**OCHC 214 Somerset**

Design Brief

214 Somerset St. E., Ottawa, ON, K1N 6V4  
*CSV project # 2022-2471*

**December 24, 2024**

1 TREE CONSERVATION REPORT & LANDSCAPE PLAN
SCALE: 1:100

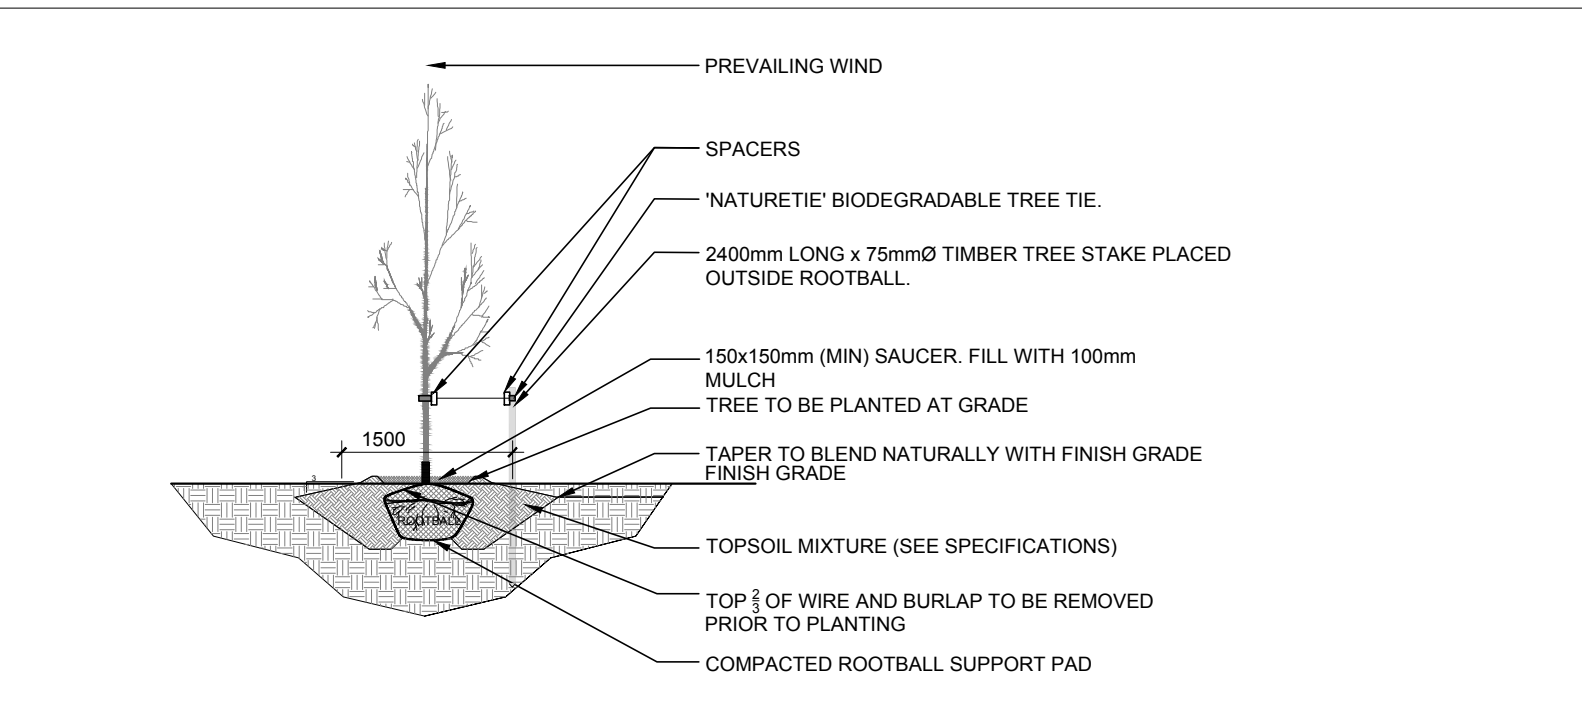
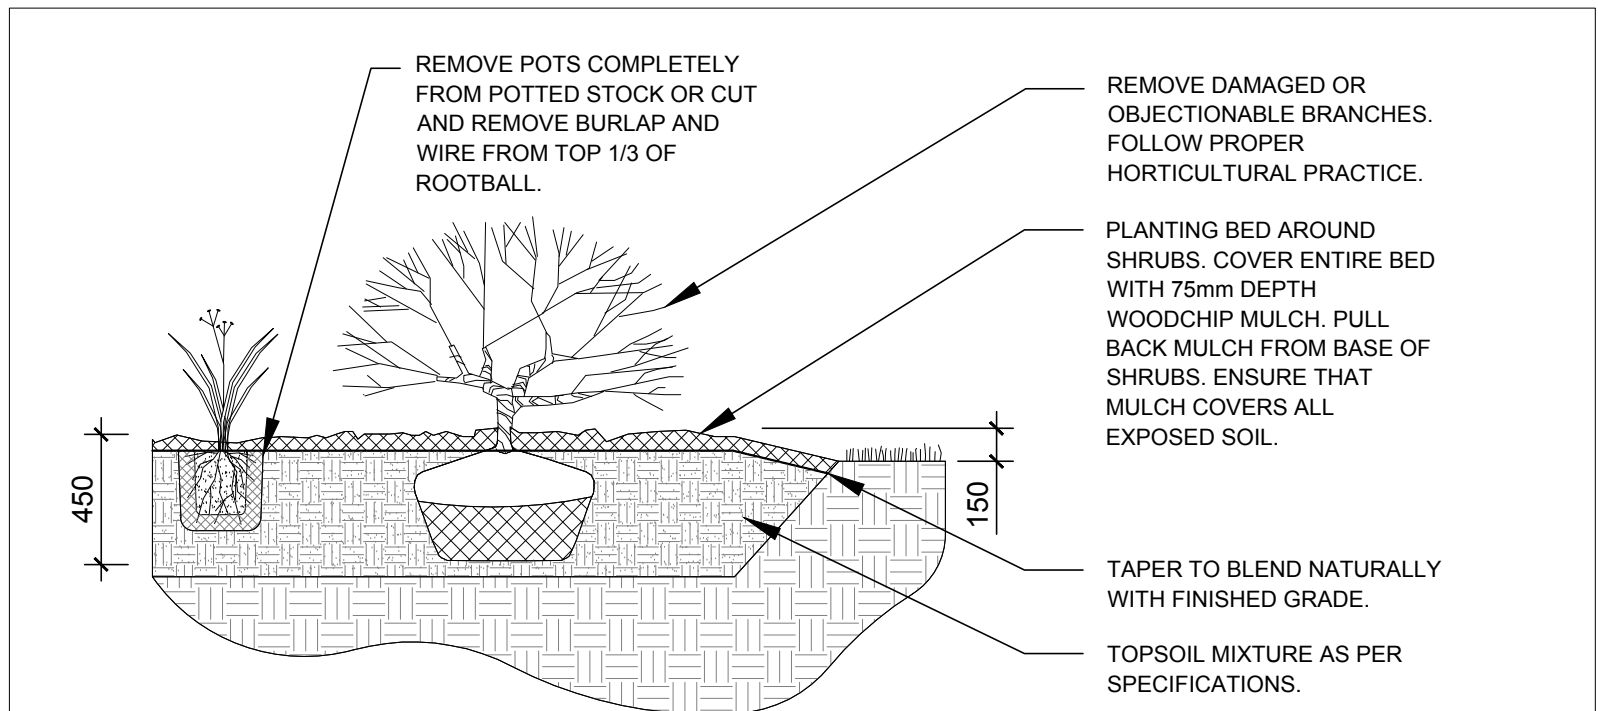
*3. Explore the potential for additional tree planting.*

Response: There is limited area that will support tree planting. The frontage along Somerset is limited by existing hydro lines. Also, due to soil conditions, trees within 10 m of the foundation must meet the 2.1 m embedment requirement set out by the City of Ottawa. The foundation-to-tree setback is considered 4.5 for small to medium trees due to the presence of the clay soils and the City guidelines. There is one small tree planned for planting in the rear yard amenity space.

1 SITE PLAN - NEW WORK
A100 1:100

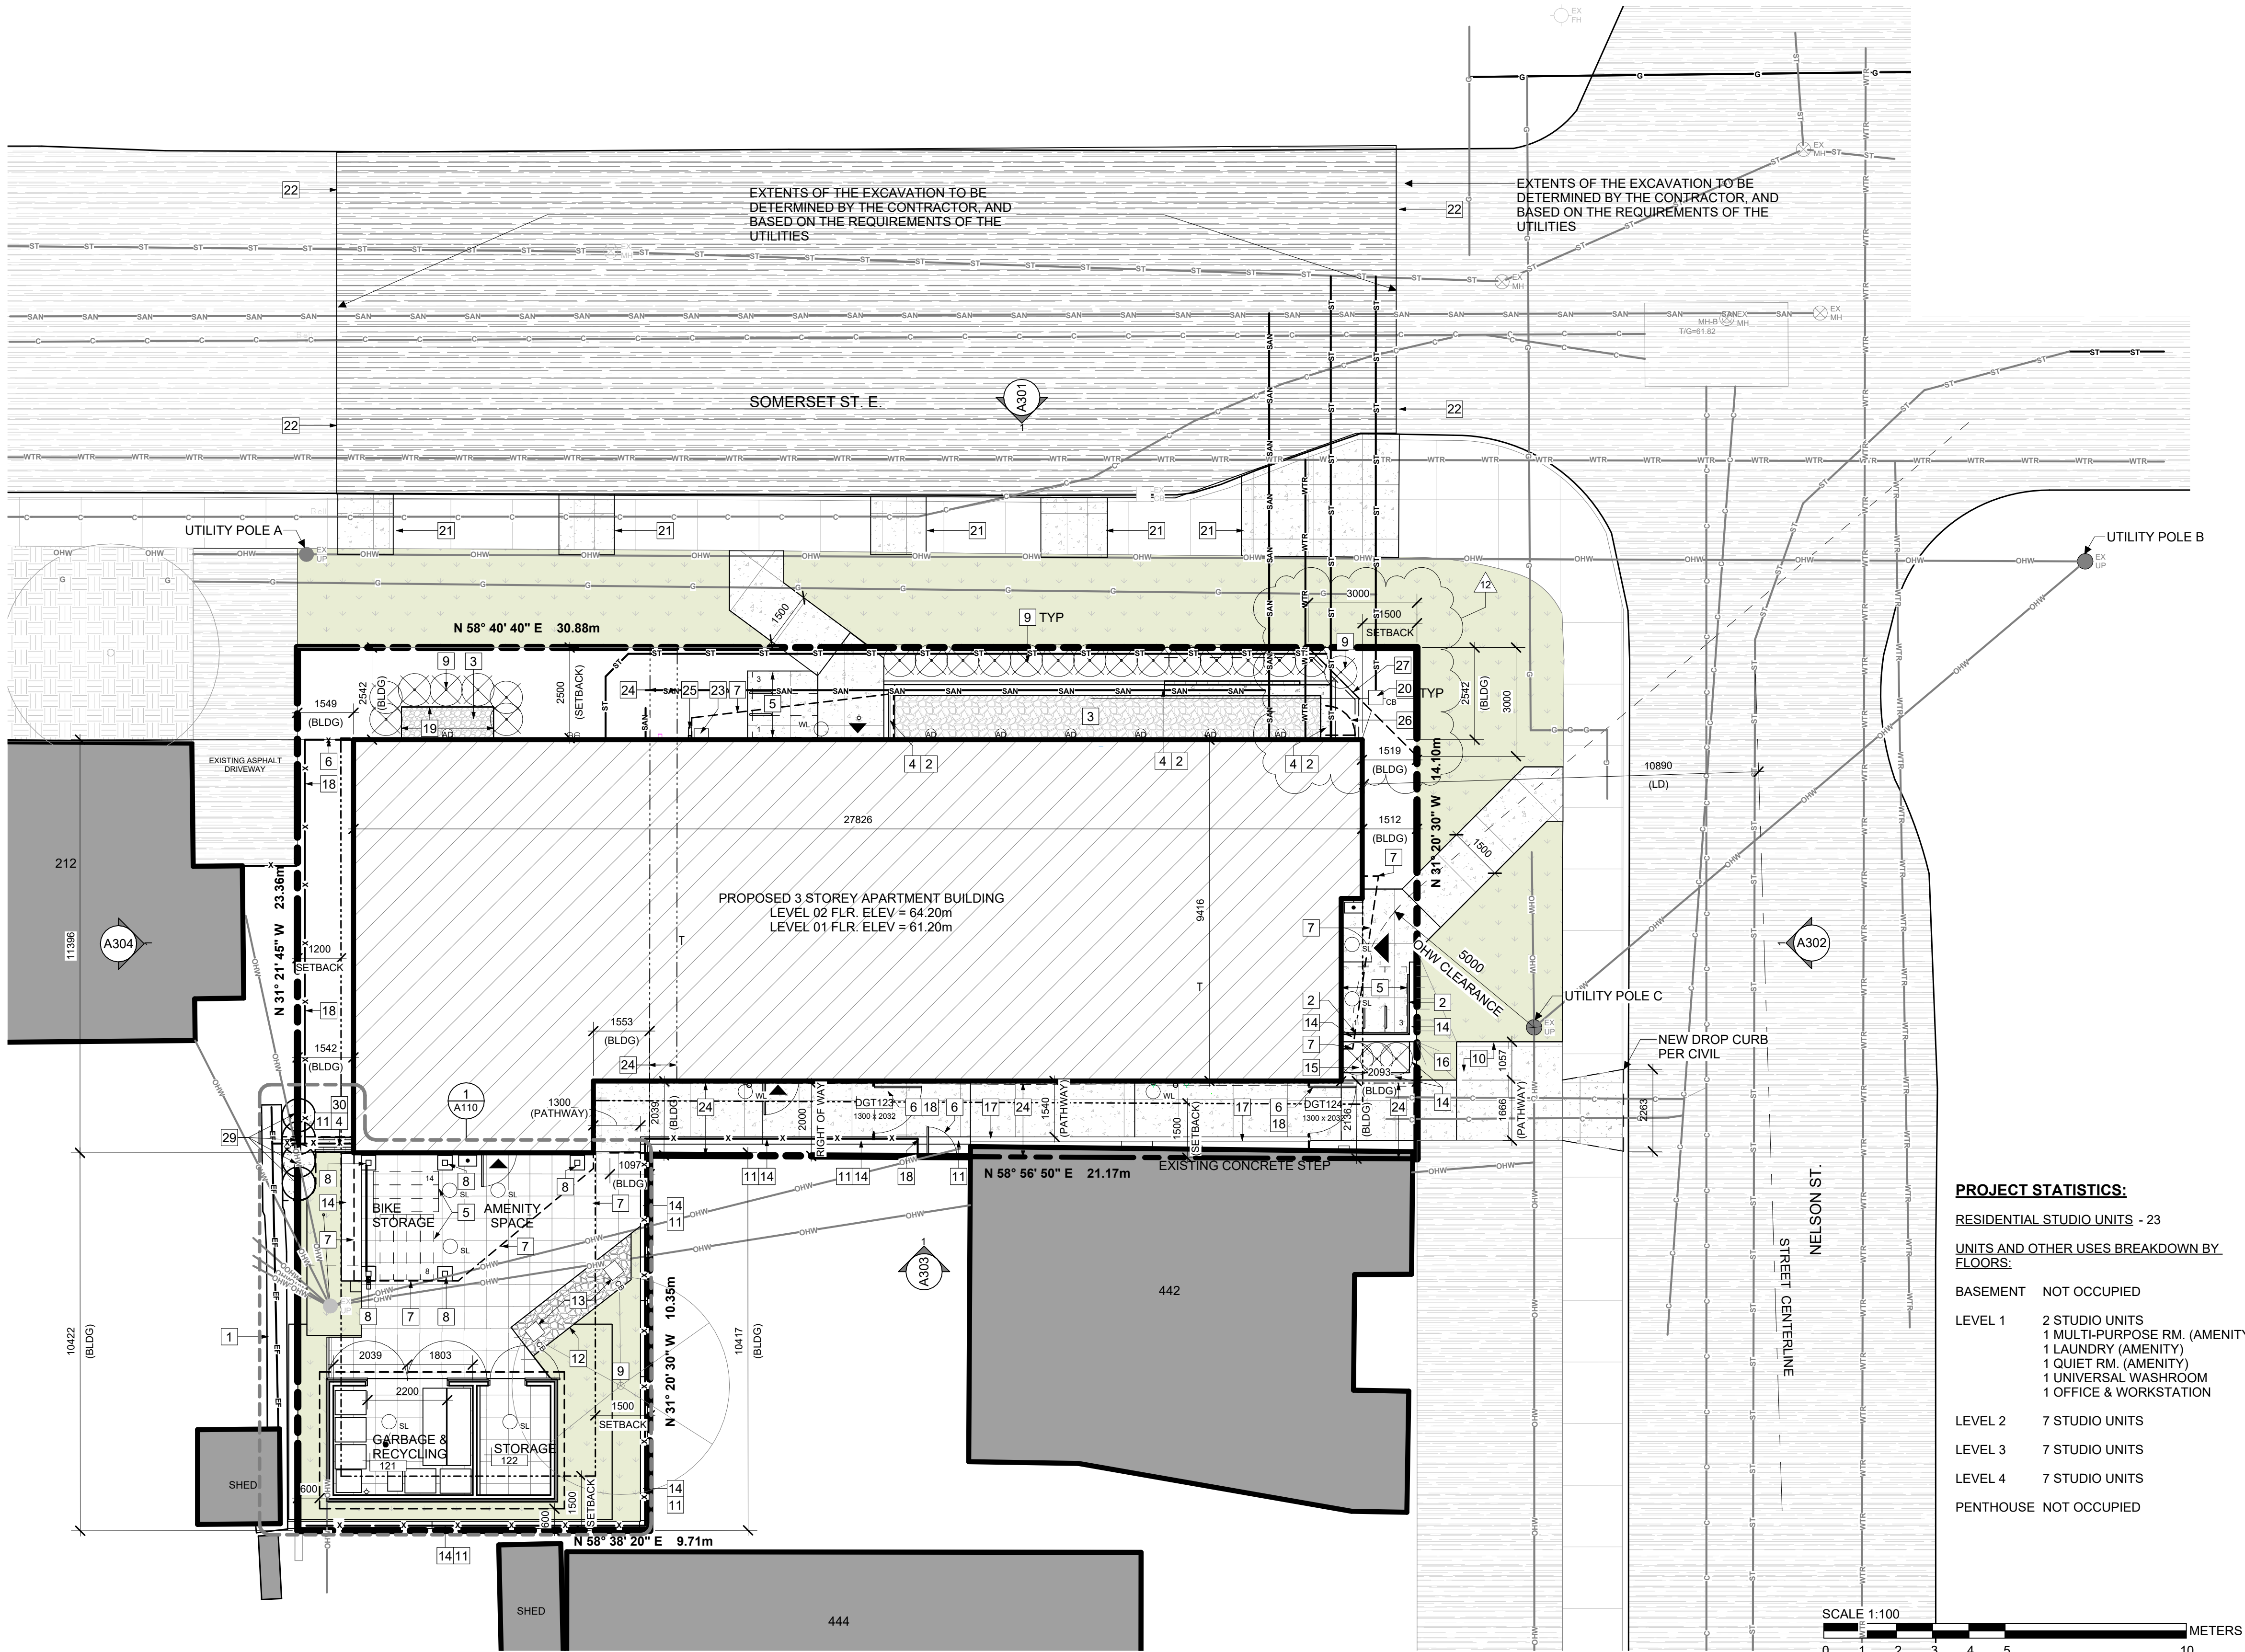
4. City Staff asked the team to show light fixtures on the initial plan.

Response: These are indicated on the Site Plan provided.
